City of Portland, Maine - Building or Use Permit Application
 389 Congress Street, 04101 Tel: (207) 874-8703, Fax: (207) 874-8716

Location of Construction: 138 Auburn St	Owner Name: First Lutheran Church Of	Owner Address: 132 Auburn St Portland, Me. 04103	Phone: 207-797-2525
Business Name: n/a	Contractor Name: Mainland Structures, Inc.	Contractor Address: Po Box 128 Gorham	Phone: 2078561817
Lessee/Buyer's Name: n/a	Phone: n/a	Permit Type: Additions - Commercial	Zone: R-3

RE: Addition and Renovations to First Lutheran Church, 132 Auburn St.

RE: First Lutheran Church, 132 Auburn Street
(ID# 20010012, CBL# 374-A-13)

SHEET TITLE
EXTERIOR ELEVATIONS

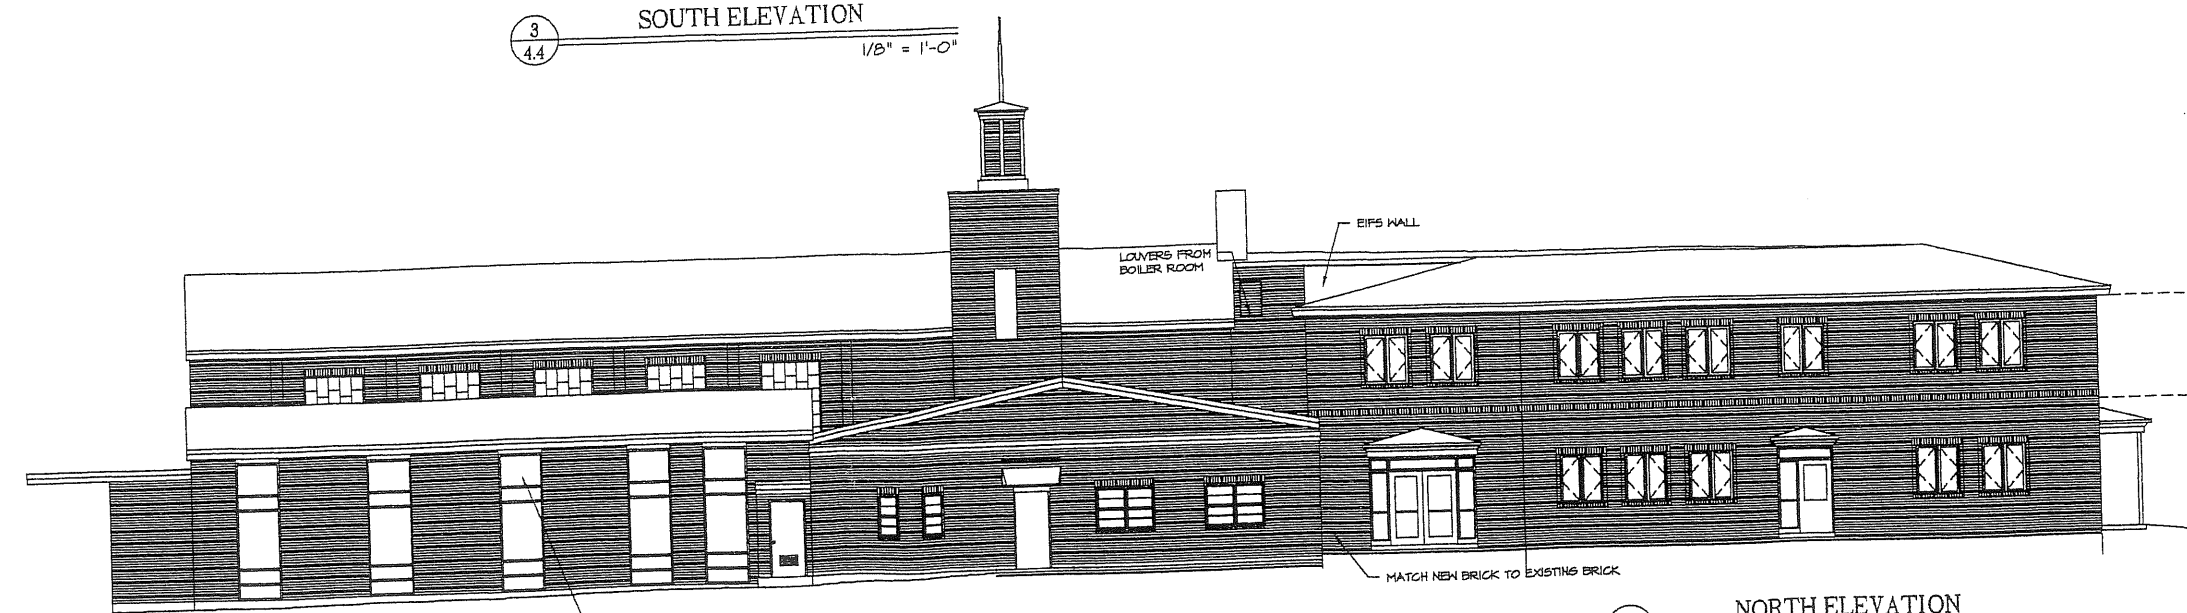
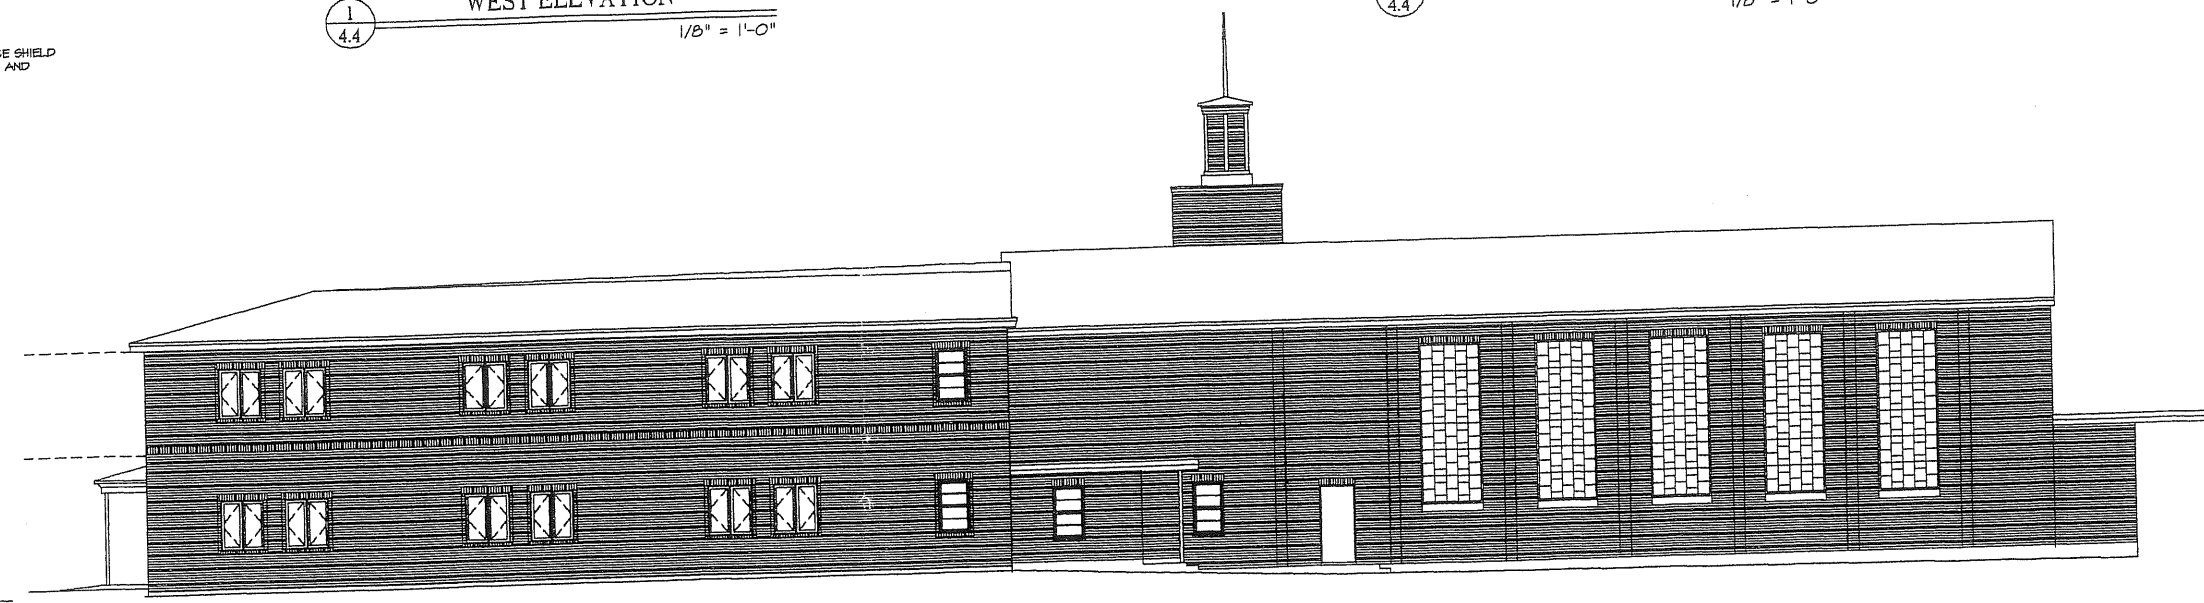
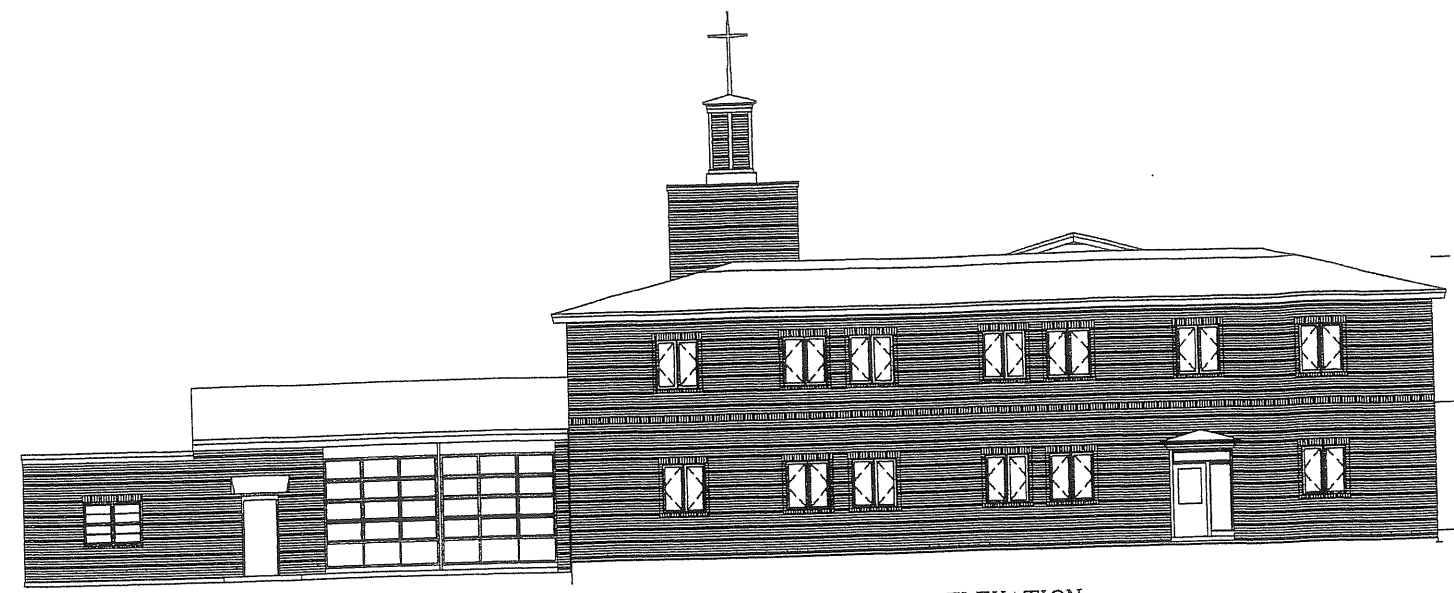
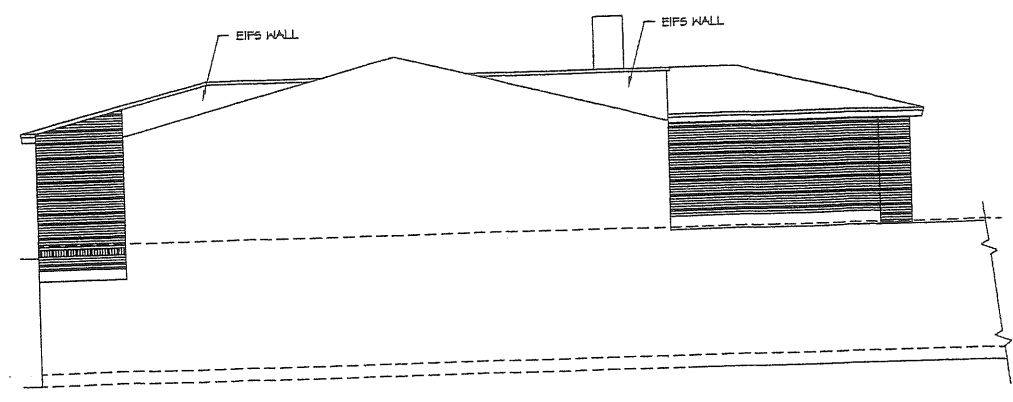
Height - 2 stories - 35' max - 27' scaled

PLAN
1" = 30'

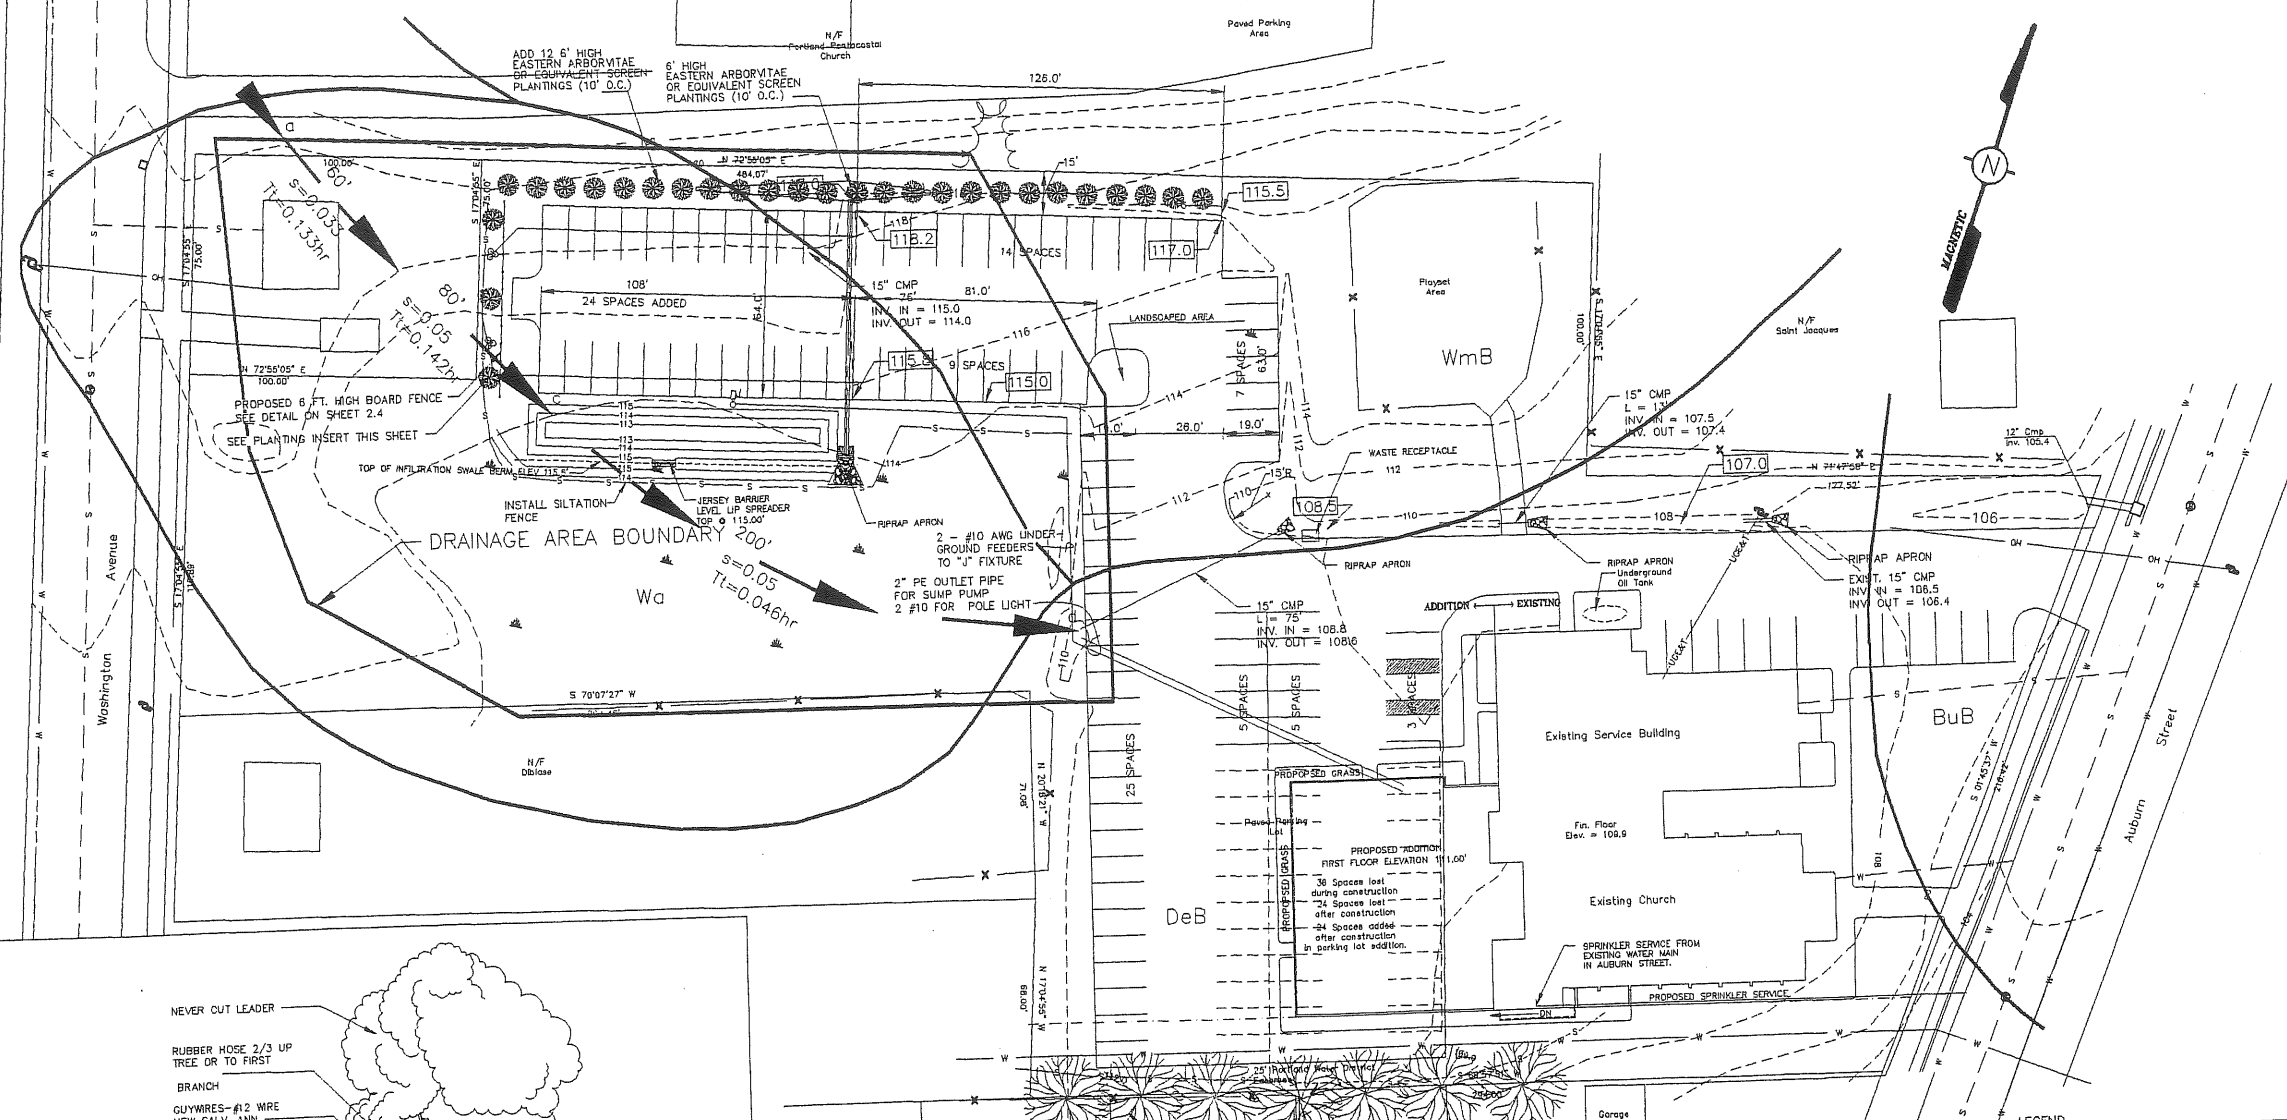
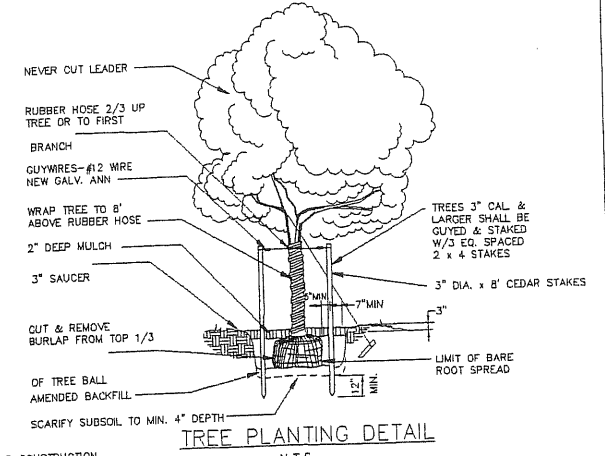
- i. that the site plan be amended to designate the land at the west end of the new parking lot as an area to remain free of snow storage and that the area to the south of the lot be specified as a snow storage location.
- ii. that the landscaping element of the site plan be amended to include the placement of 6' high Eastern Arborvitae 10' on center between the parking area and the western property line behind the proposed addition.
